Suffolk County Council (20041323)

Post-Hearing Submission for the Third Issue Specific Hearing (ISH3) into Transport and Rights of Way

Bramford to Twinstead (EN020002)

Deadline 4

Reproduced from Ordnance Survey maps by permission of Ordnance Survey on behalf of the controller of His Majesty's Stationery Office. © Crown Copyright Ordnance Survey, Licence no. 0100059731

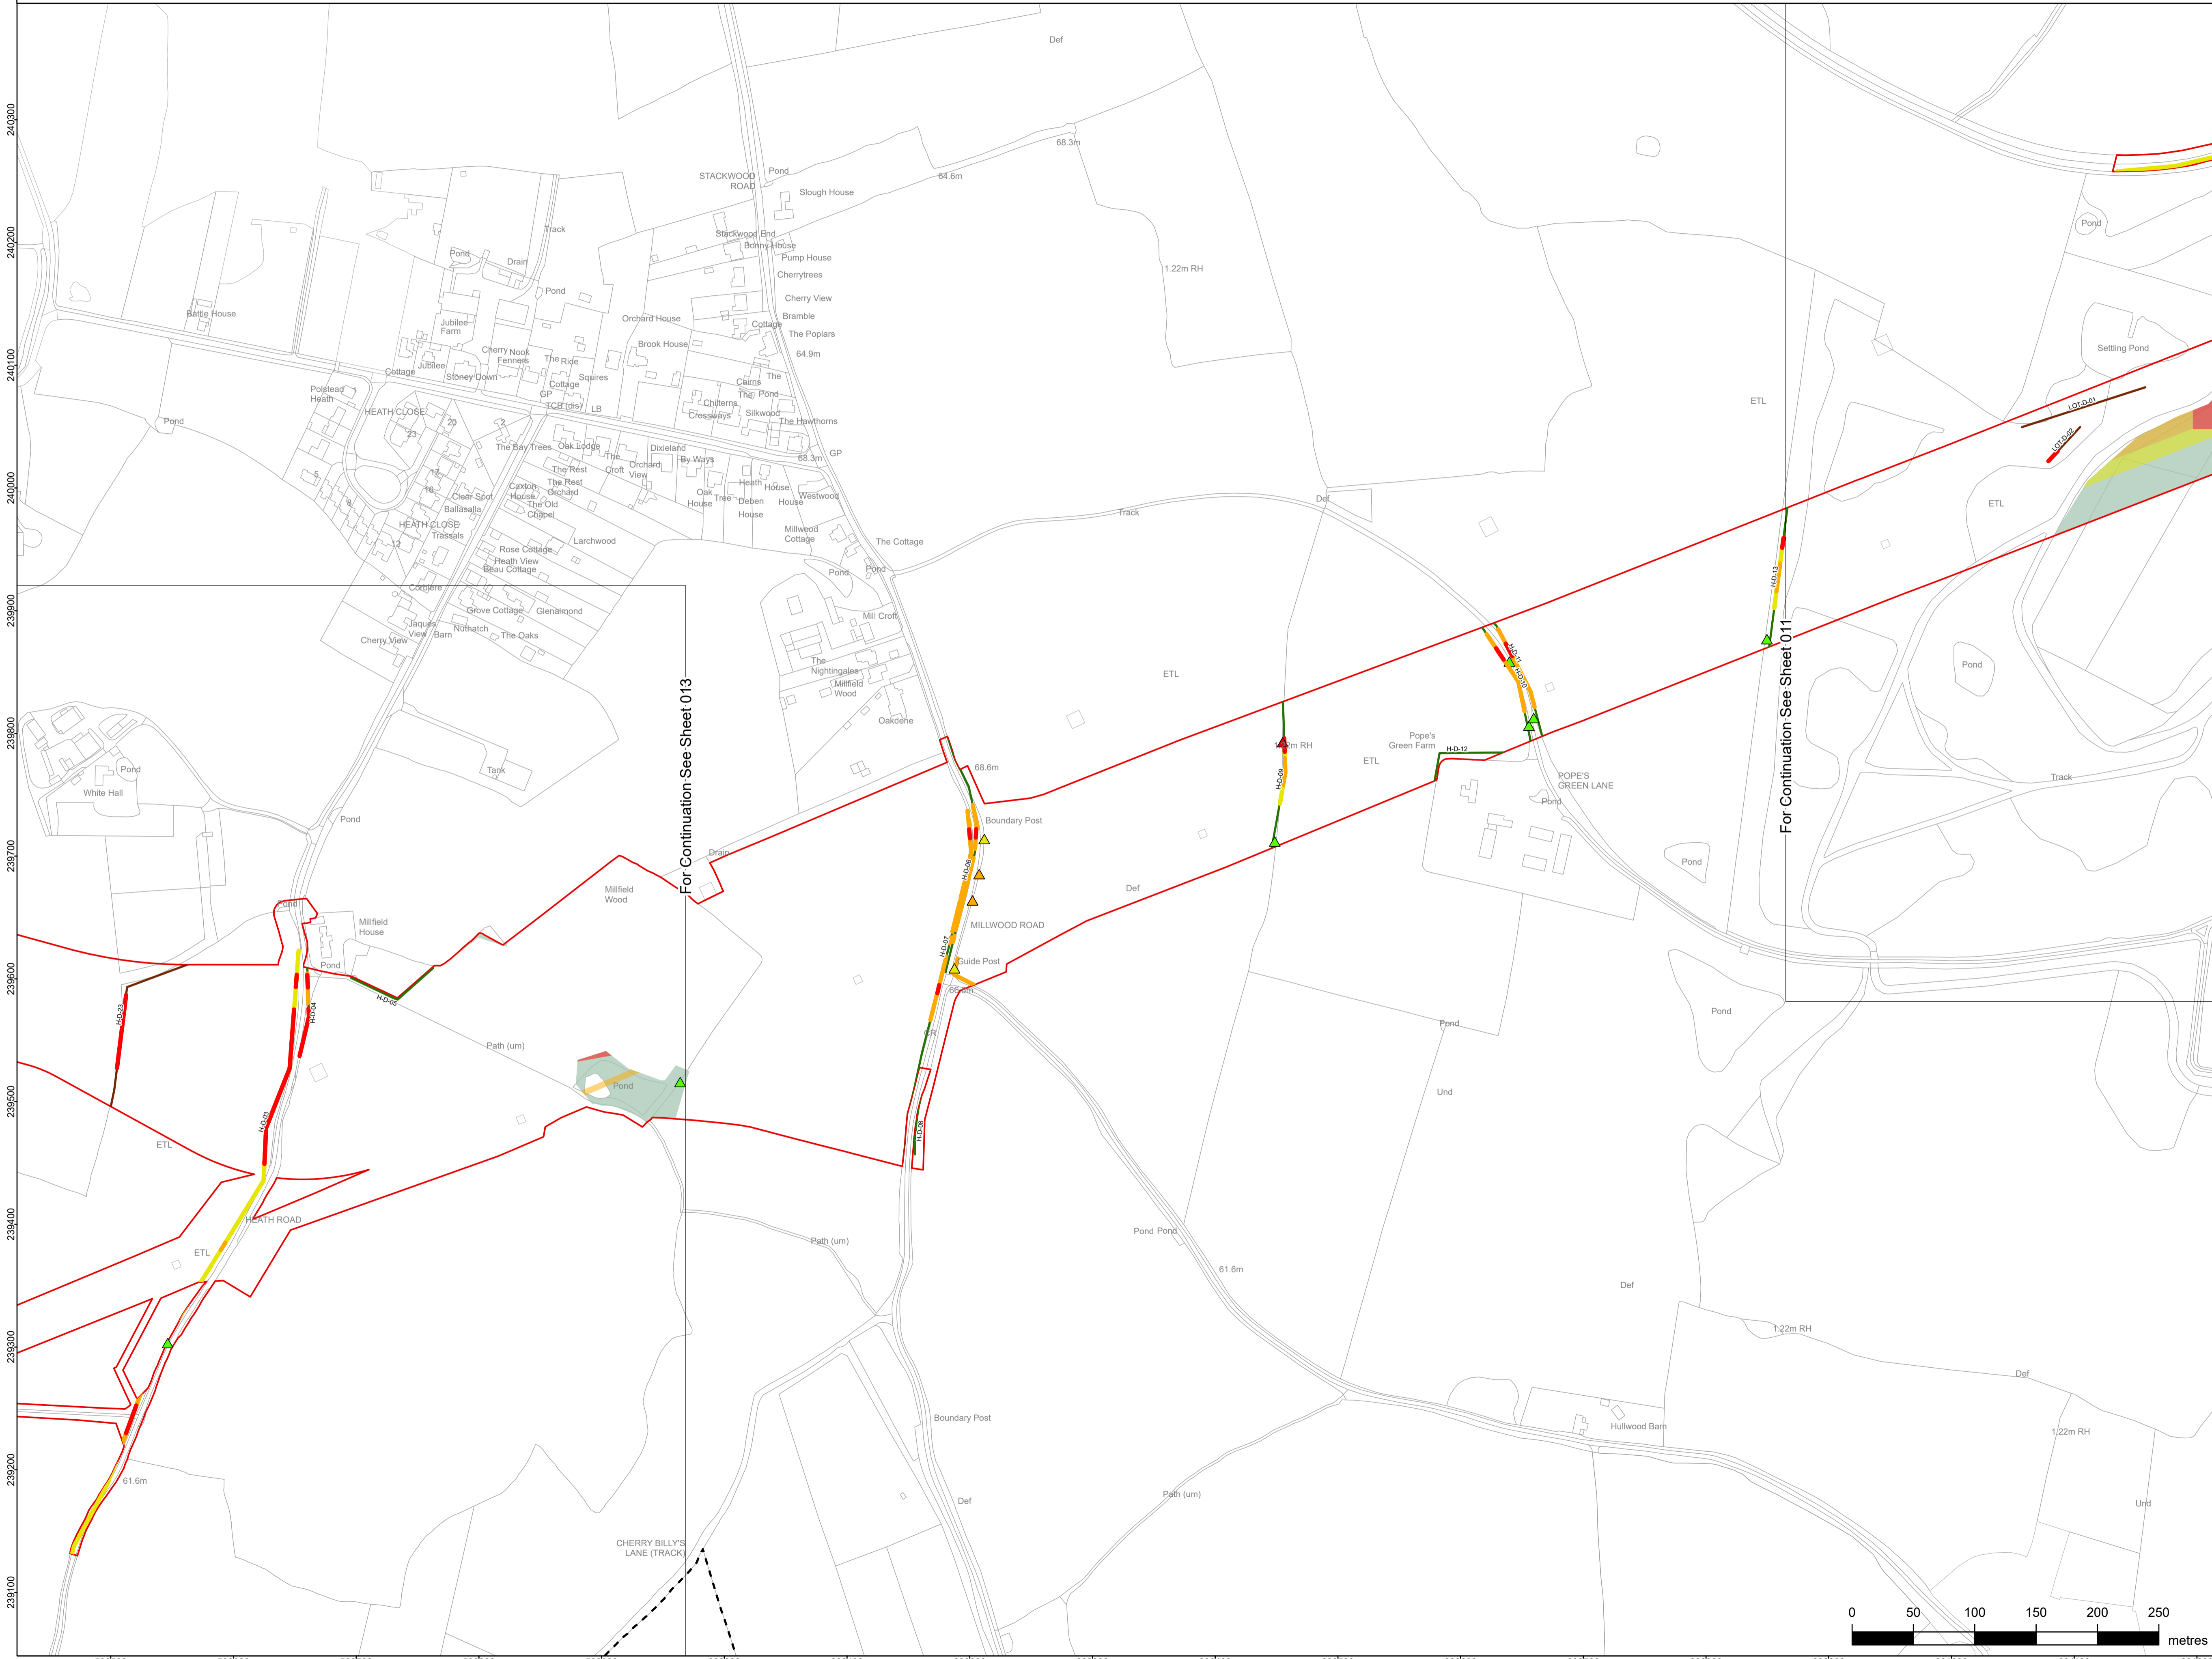
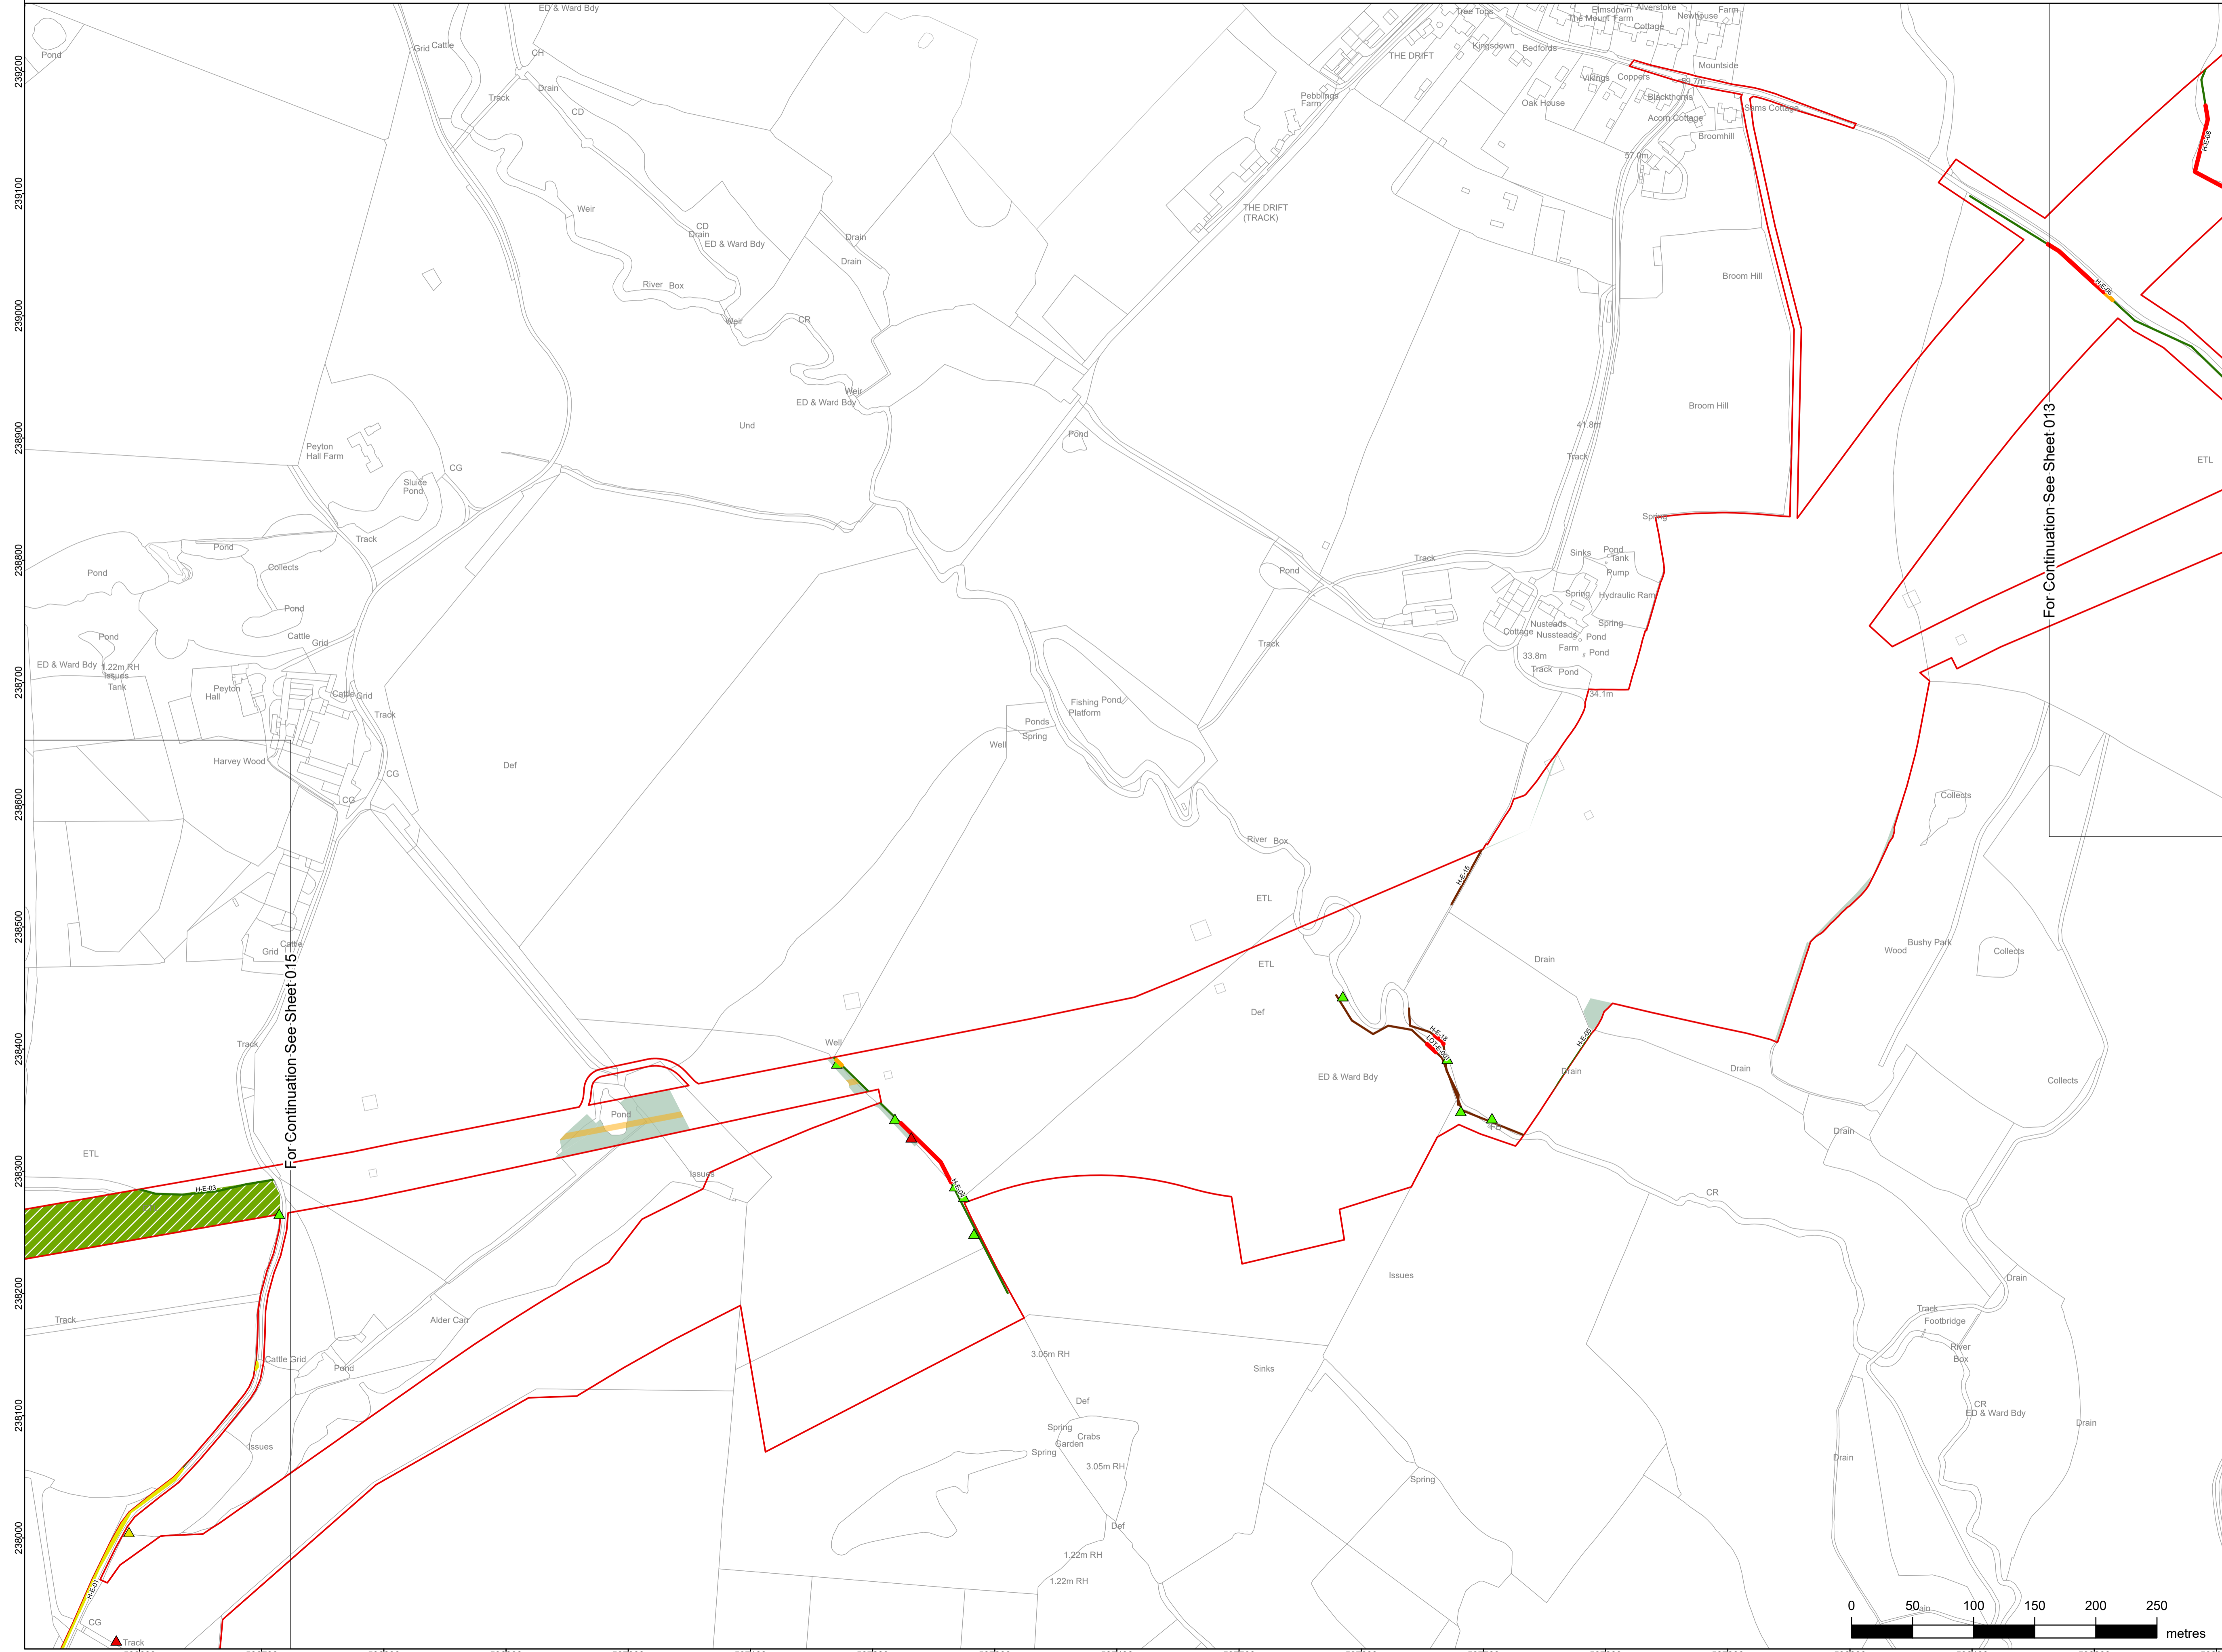
The plans provided are of such large scale to make it difficult to measure the areas proposed for visibility splays.

An example from Church Hill, Burstall in our option shows the issues. The road is currently derestricted but will be subject to a temporary 30mph limit during construction. Even allowing for such a temporary speed limit having good compliance, this will still require a 2.4m x 90m visibility splay as required as by the Suffolk Design Street Guide 2022 Appendix F (see Appendix 1). This would necessitate significant trimming if not removal of trees and hedges. SCC also notes that pollarding / raising the crown of trees whilst practical for individual trees would not resolve the visibility issues if there were a line of trees.

A second example is the permanent access D-DAP2 off Millwood Road, Polstead. The road is derestricted (60mph) and as the temporary speed limit will be remove post construction will require a 2.4m x 215m visibility splay to conform with design standards in the operational phase. The 'Trees and Hedgerows to be Removed or Managed Plans' sheet 12 only shows the hedges to be coppiced which unless repeatedly cut (to 600mm agl) would not provide acceptable visibility. It is noted that the visibility for D-DAP4 on inside of the bend will also be poor.
